MEMORANDUM

TO: Jean Fraser, Planner
FROM: Lauren Swett, PE
DATE: May 9, 2017
RE: Second Tee Condominium Association Business Park Unit 15, Level II Amended Site Plan Response to Comments

Woodard & Curran has reviewed the Level II Amended Site Plan Application for the proposed development located at 1039 Riverside Street in Portland, Maine. The project involves the construction of the Unit 15 building, parking, utilities, and ancillary features.

SHEET TITLE
**GRADING, DRAINAGE AND
EROSION CONTROL PLAN**

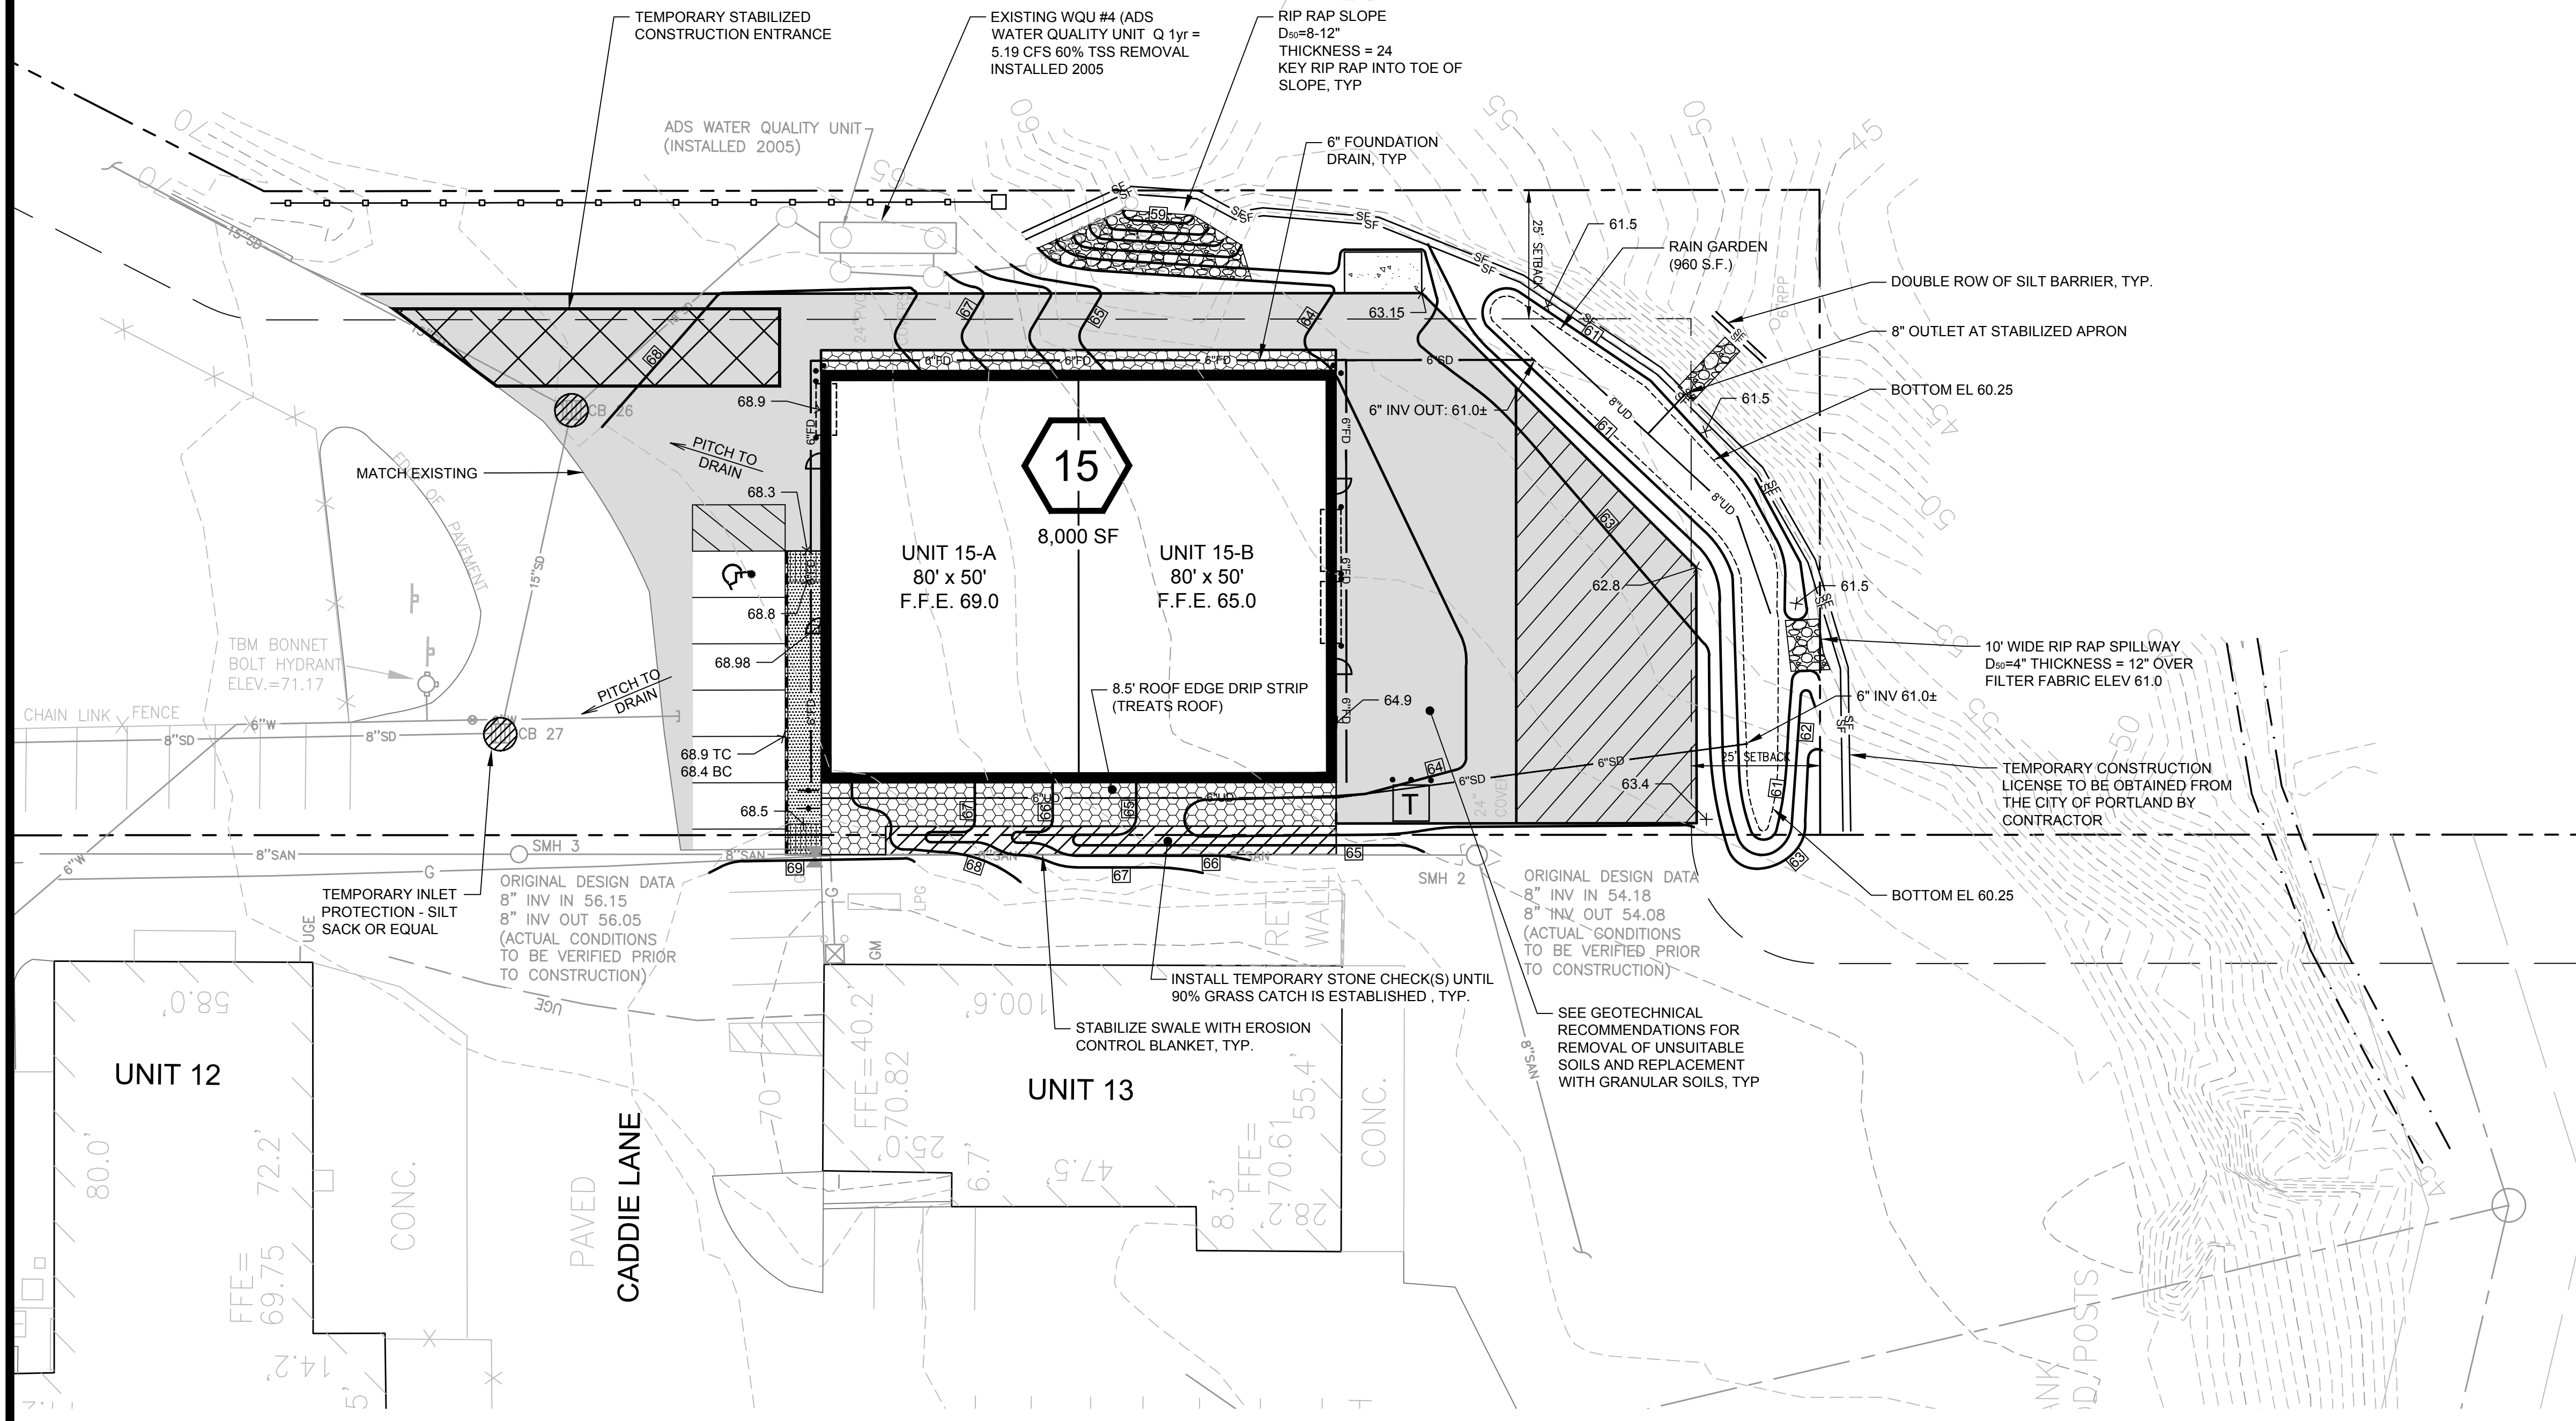
- 2) *We recommend providing rip rap or other erosion control at the underdrain outlet of the roof line drip strip filter to the proposed rain garden.*

- c) Flooding Standard: The Applicant has requested a waiver of the Flooding Standard based on the project's location within the Presumpscot River Watershed as has previously been considered for the site. We do agree that the roof drip edge filter and rain garden will help attenuate the rate of runoff and we would support the granting of this waiver.
